# Easement Enquiry Design Advice

### Response to Easement Enquiry: 2020-023 – Modification to Oakdale West (SSD-7348-MOD-1)

Item	Notes
Customer/Project	Goodman – Industrial Development, Oakdale West Estate
Date Enquiry Received	14/01/2020
Date Response Required by	ASAP
Outline of Proposed Works by Customer	<p>This enquiry is for a section 4.55 (1A) modification (V7 drawings) to an existing application. The modifications include;</p> <ul style="list-style-type: none"><li>• The addition of batter and earthworks either side of the Western/North-South link road into TransGrid easement</li><li>• The addition of Bio-retention Basin No.1</li><li>• The relocation of Bio-retention Basin No.5 (now called Basin No.4) closer to TransGrid structures and more directly under conductors</li></ul> <p>The previous assessment completed by TransGrid was in 2017 and was under assessment 2017-363. This assessment viewed drawing suite V1.</p>
Details of Assets Impacted	<p>330kV TL 30 Sydney West - Liverpool, Span 6-10</p> <p>330kV TL 14 Sydney North – Kemps Creek, Span 104-108</p>

Title
BULK EARTHWORKS CUT/FILL PLAN

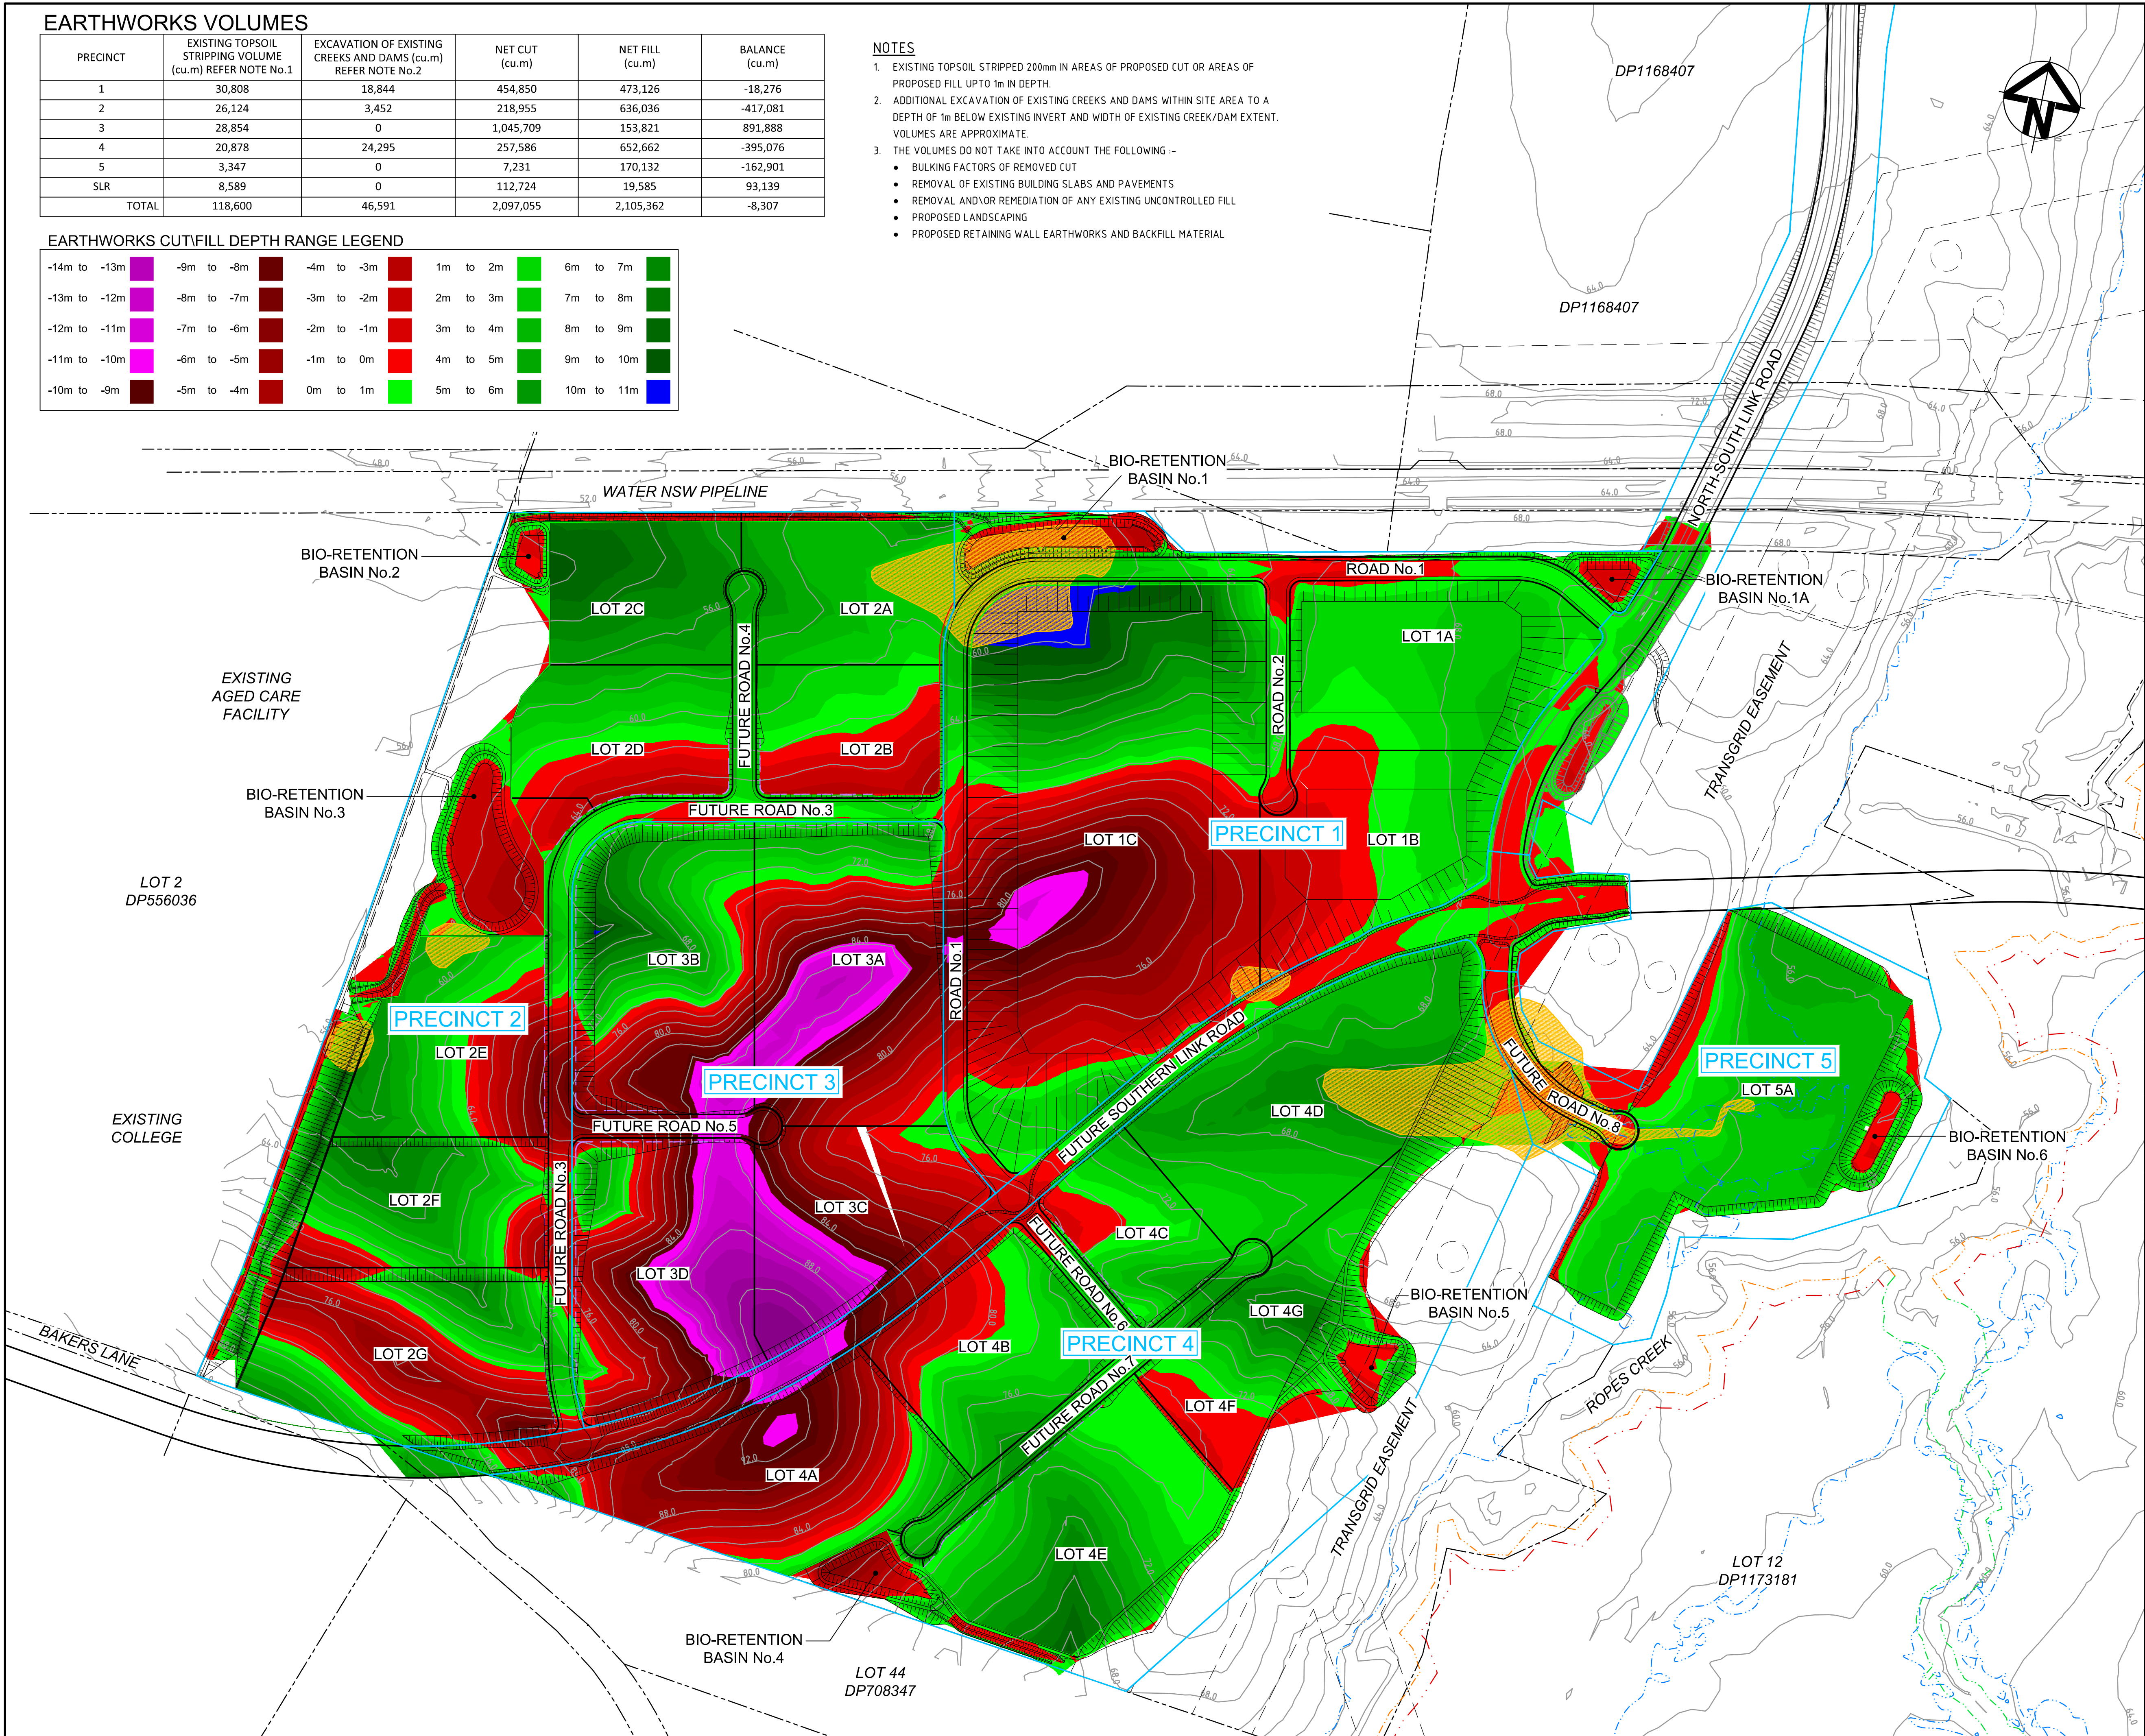
- Proposed ground has clearance to the 330kV aerial conductors at span of 106-107 of **TL14**, of 9.35m, where the conductor is sagged at maximum operation temperature of 120°C. This is compliant to AS/NZS:7000 clearances.
- Proposed ground has clearance to the 330kV aerial conductors at span of 107-108 **TL14**, of 8.76m, where the conductor is sagged at maximum operation temperature of 120°C. This is compliant to AS/NZS:7000 clearances.
- Structure Exclusion Zone;
  - To Tower 106 is 87.2m
  - To Tower 107 is 22.5m

- Proposed ground has clearance to the 330kV aerial conductors at span of 8-9 of **TL30**, of 9.73m, where the conductor is sagged at maximum operation temperature of 120°C. This is compliant to AS/NZS:7000 clearances.
- Proposed ground has clearance to the 330kV aerial conductors at span of 9-10 **TL30**, of 8.85m, where the conductor is sagged at maximum operation temperature of 120°C. This is compliant to AS/NZS:7000 clearances.
- Structure Exclusion Zone;
  - To Tower 9 is 21.5mm to Lot 5A access road
